PC Comment Response Letter

January 13, 2023

Subject: Intake Screening Comment Response Letter
Address: 7929 East Mercer Way
Permit: 2211-165
To: City of Mercer Island

SITE PLAN
 PARCEL NO. 3024059176
 7929 EAST MERCER WAY
 MERCER ISLAND, WA 98040

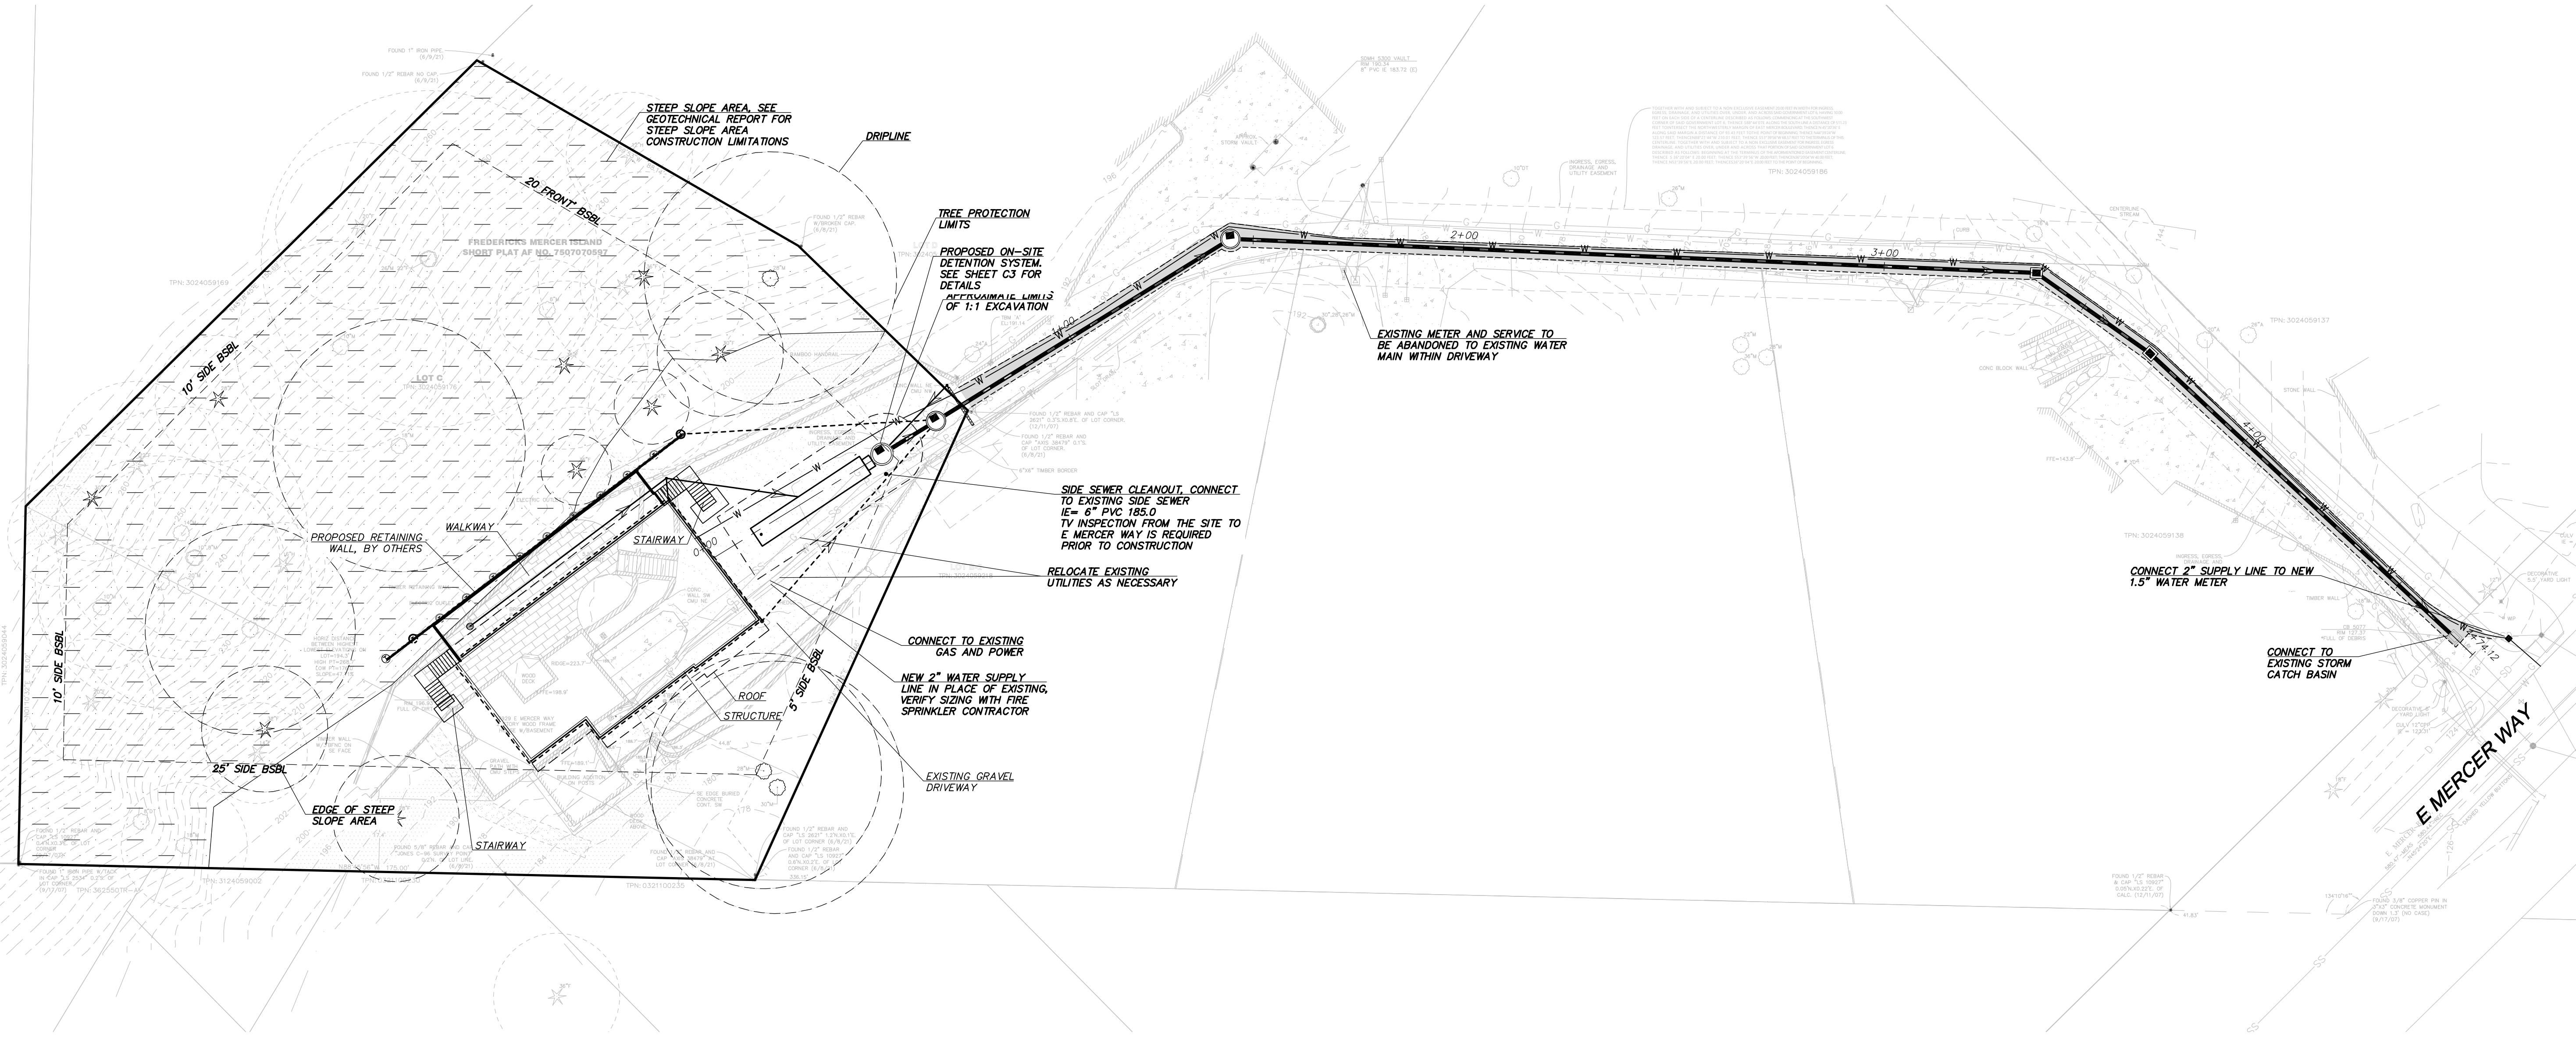
3. Provide Lot Coverage, Hardscape, & GFA Calculations.

5. Garage Area Inclusion. Lot Coverage, Hardscape, and GFA to be Removed.

Response: This information has been added to the Site Plan.

Response: This information has been added to the calculations on the Site Plan.

1 NORTH ELEVATION
A200 1/4" = 1'-0"

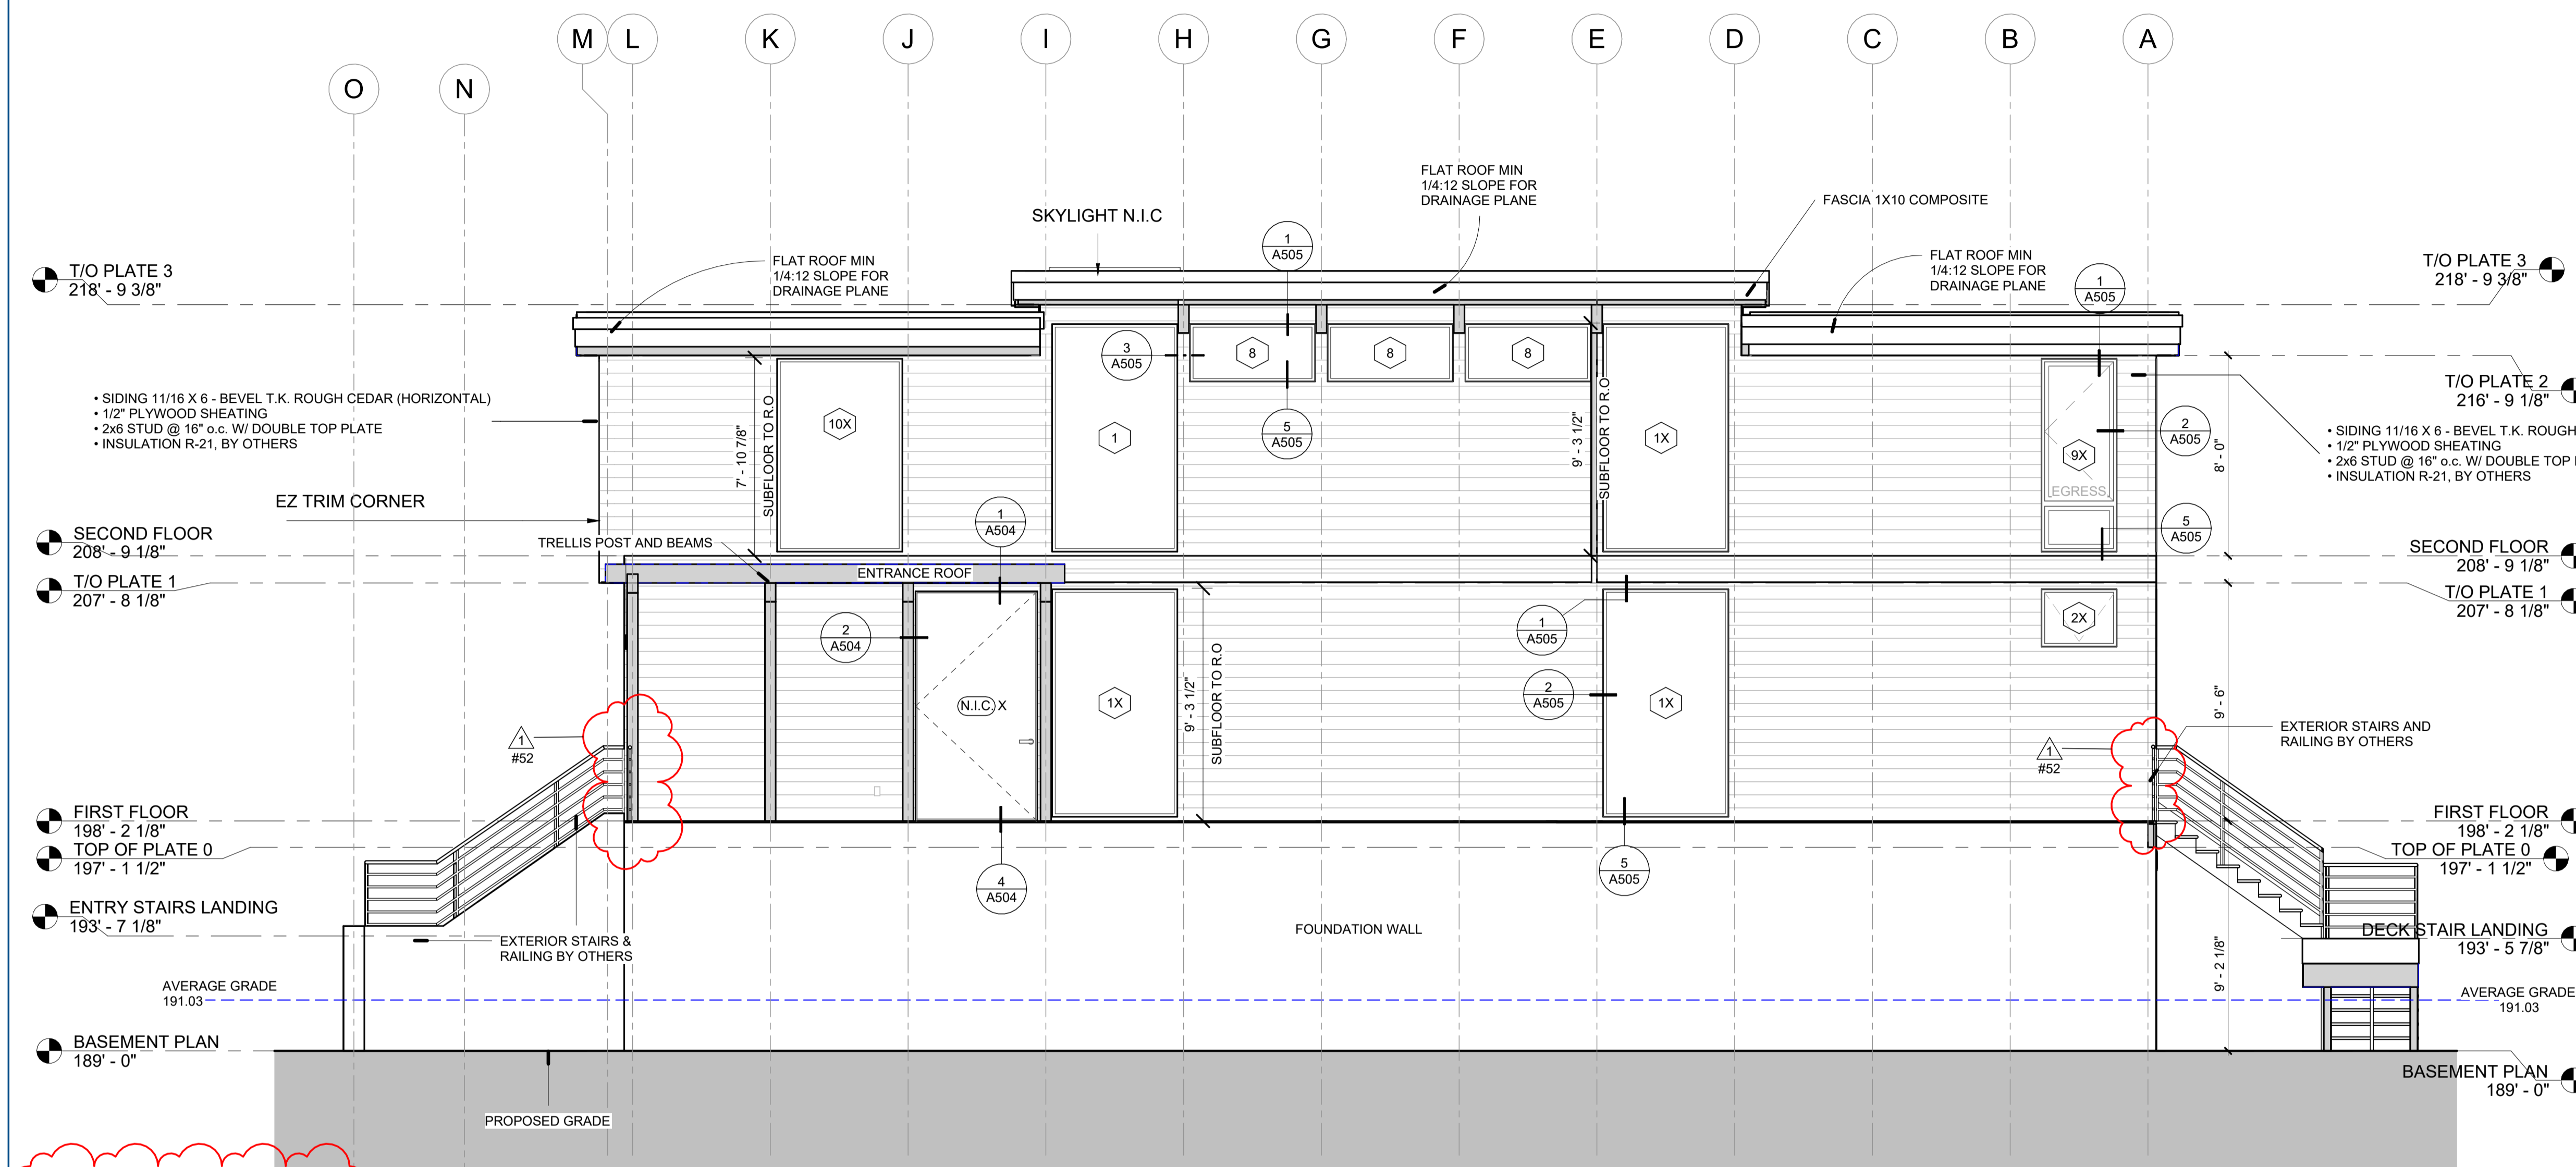
4. Elevation Drawings existing/finished grade, max downhill building façade/height, allowable building height.

Response: This information has been added to all elevations.
